APPENDICIES

TO ACCOMPANY ARCHITECTURAL DESIGN REPORT PREPARED BY

DKO Architecture

DESIGN REVIEW SUMMARY

Drawing Name
Sections

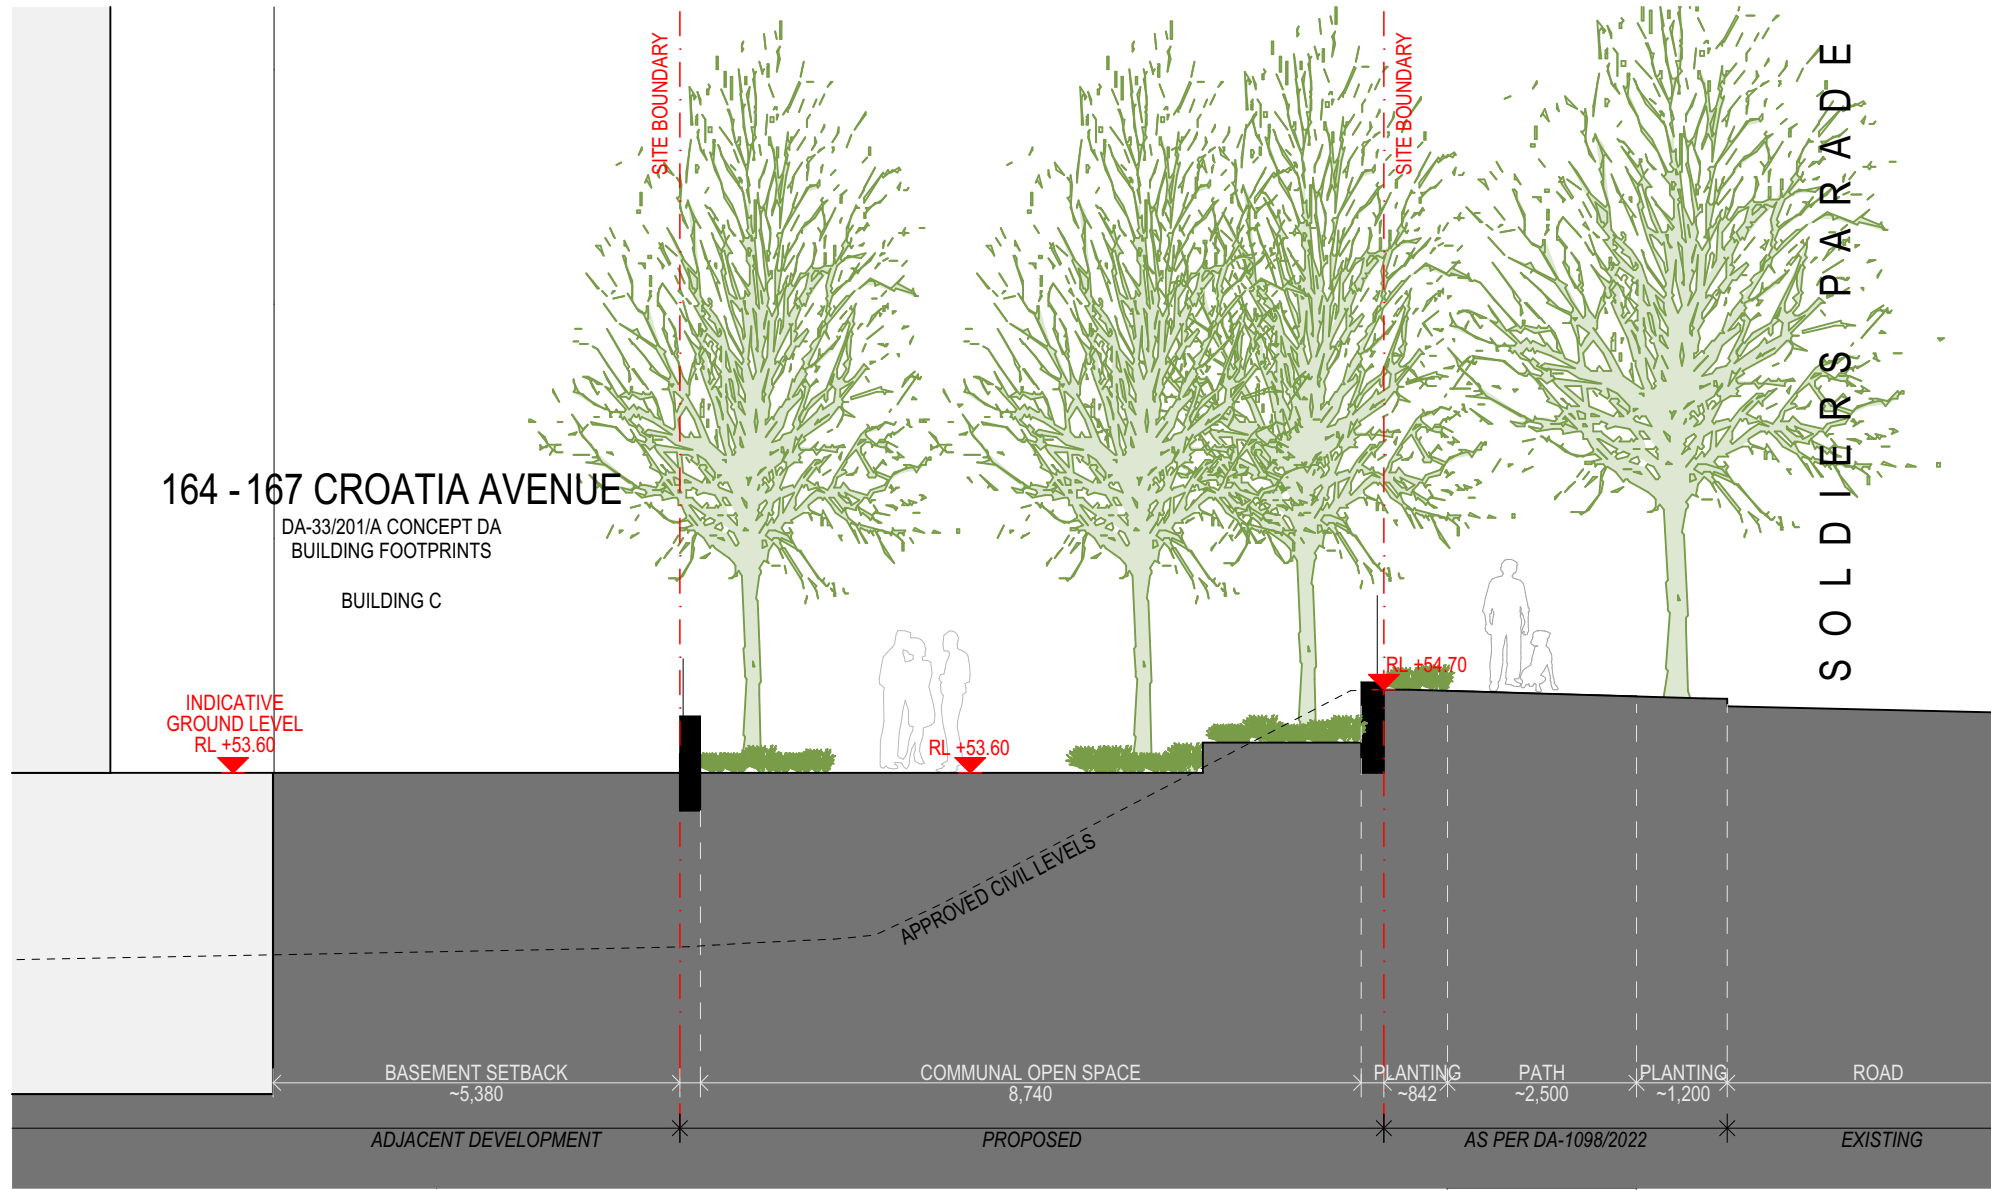
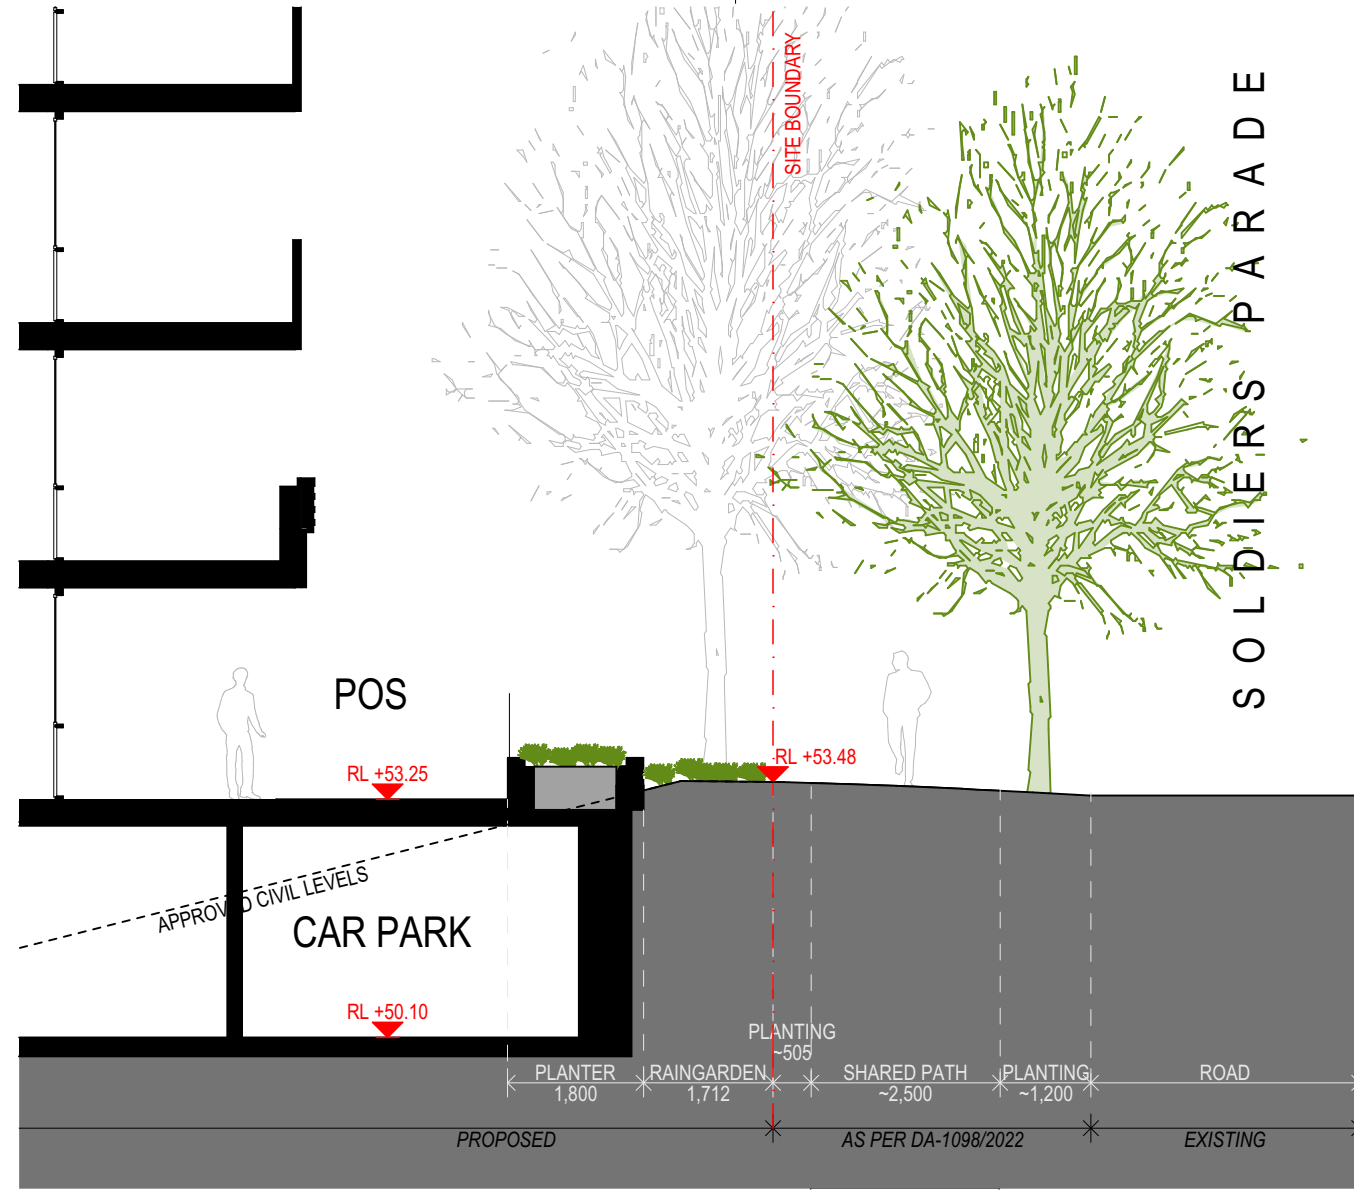
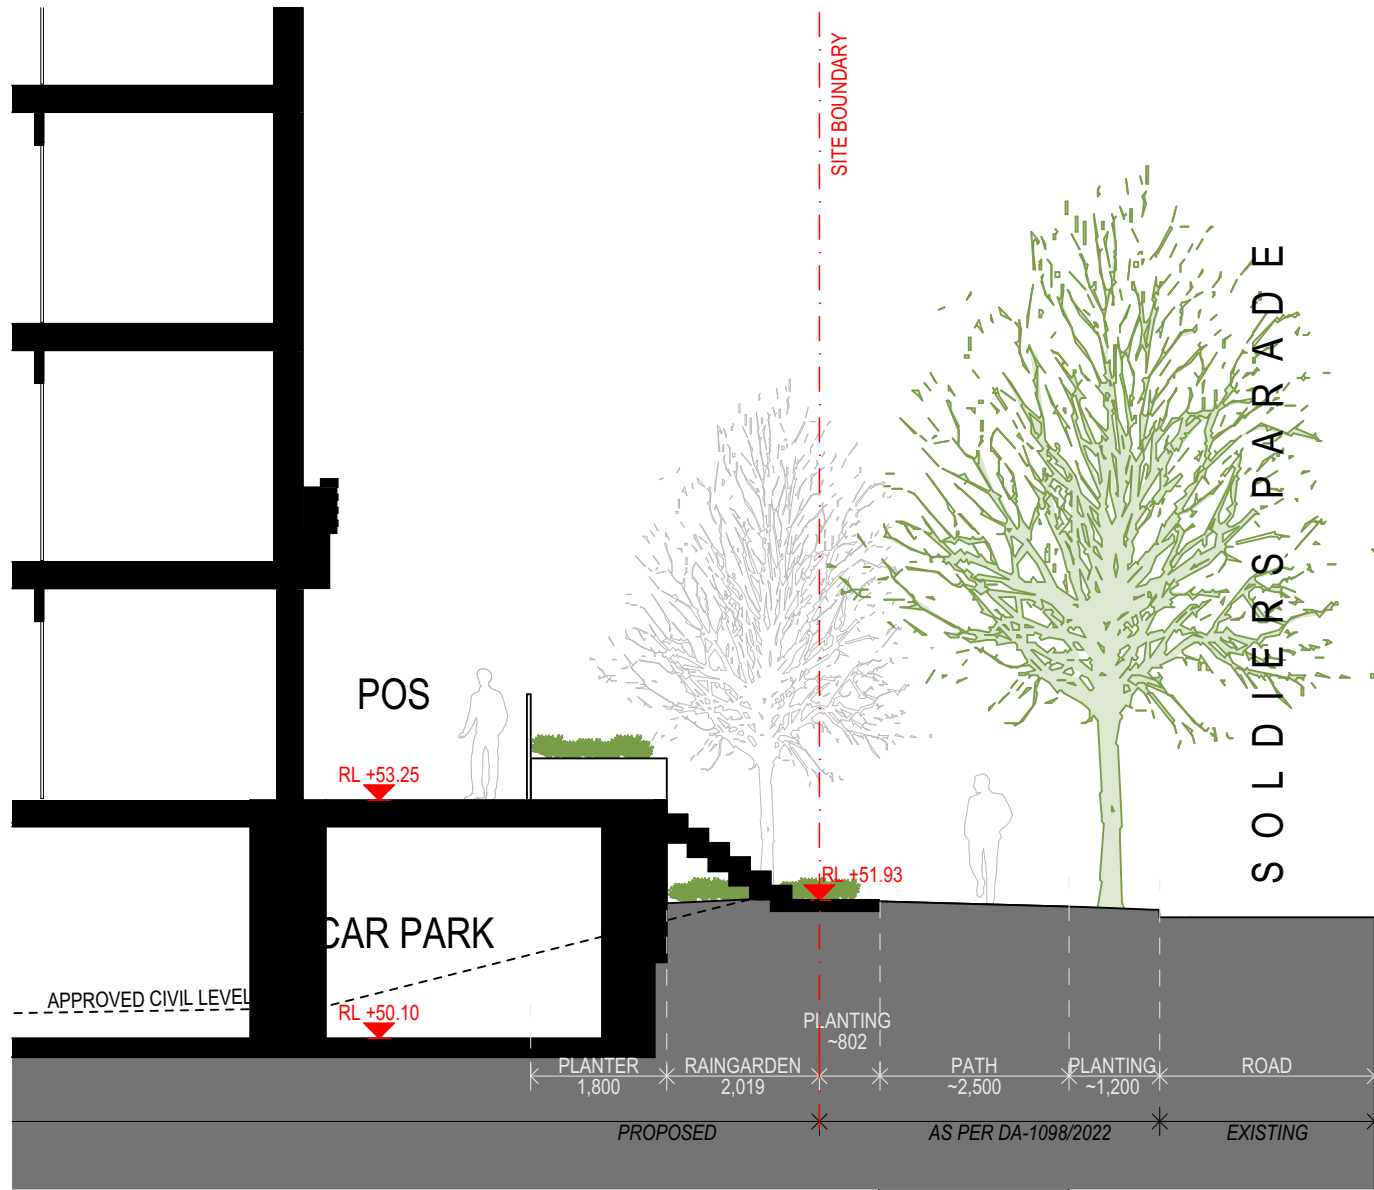
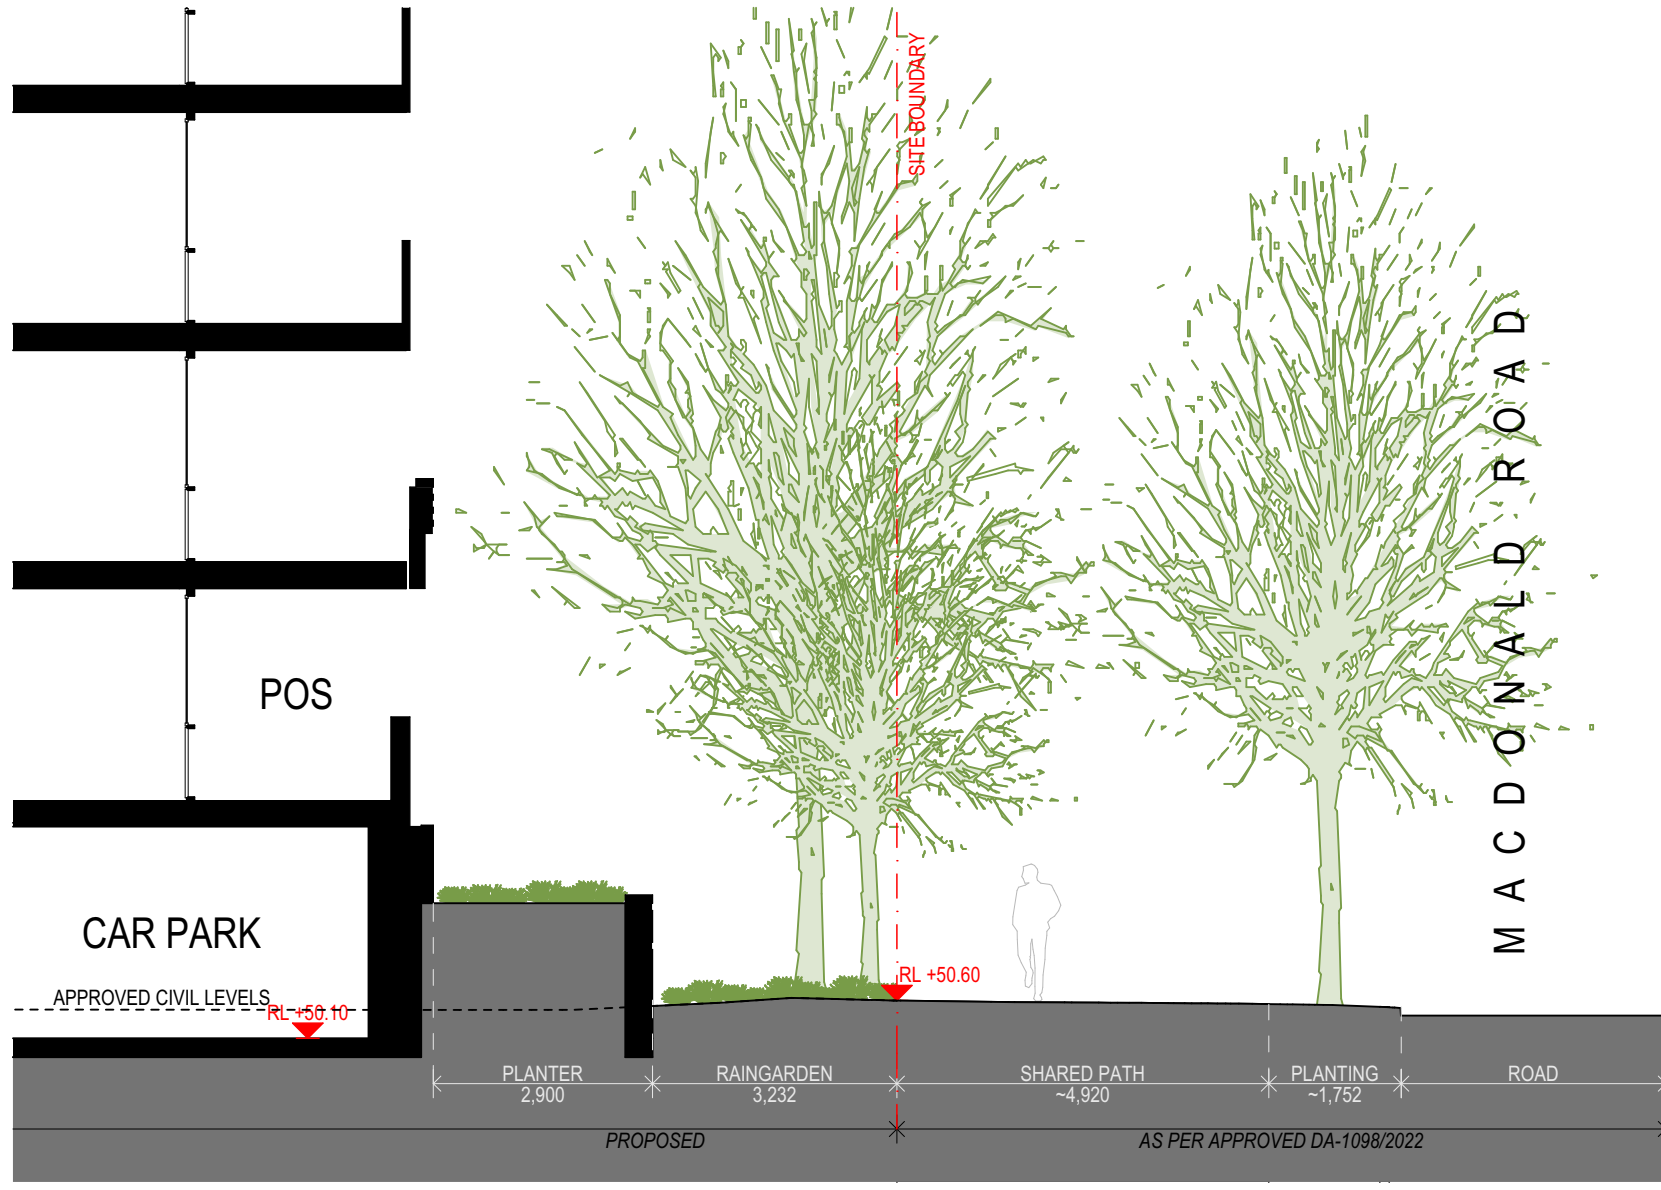
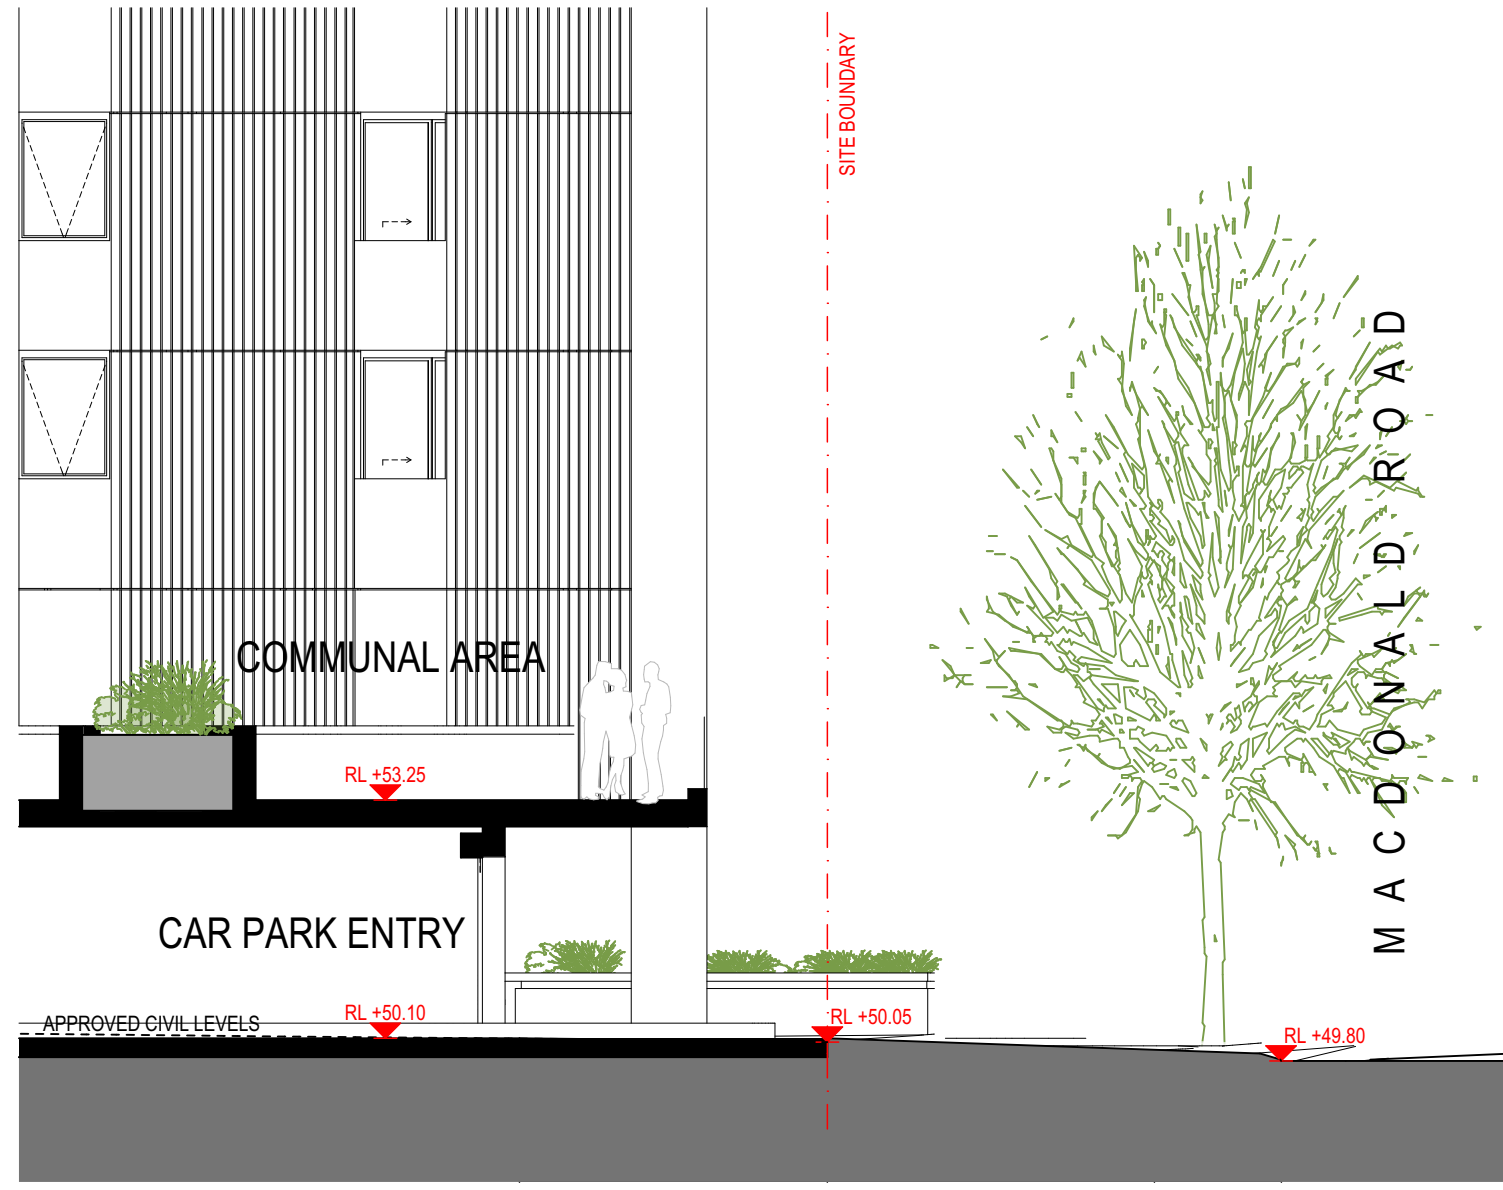
5. Landscape 5.1. CDPD is supportive of the project’s aims to achieve 40% canopy. 5.2. CDPD requests public domain interface sections illustrating the relationship between the ground and level 1 apartments, the interface with the public domain at the site boundary, footpaths, road reserve and kerb. There are crash barriers, retaining walls and level changes along Soldier’s Parade that should be illustrated on future drawings. 5.3. CDPD recommends tree and plant species selected are native and endemic to the area. CDPD requests clarity on where the species selection is being informed by – the Connecting with Country consultation, MOD 5 and/or the Liverpool Growth Centre Precincts DCP recommended species. Liverpool City Council recently released the Draft Tree Management Strategy and Technical Guidelines that should be referred to for further information and tree species and planting details. Draft Tree Management Framework Liverpool Listens 5.4. CDPD notes street trees are shown on the drawings, and seeks confirmation that the Street Trees will be delivered, as part of this project. Further detail such as spacing, pot size, planting details should be provided, and how this relates to the broader street tree approach of the Edmondson Park Town Centre and MOD 5.	5.1. Due to the bushfire requirements, we have had to reduce the canopy cover to 15%. 5.2. Public domain sections have been provided. 5.3. Endemic species have been nominated. This was informed in consultation with the Connecting with Country consultants, and research into the Cumberland Plain species and the council recommended species. 5.4. Street trees have been documented and will be delivered as part of the project. In consultation with WSP it was recommended a native species be used instead of the Fraxinus originally approved.
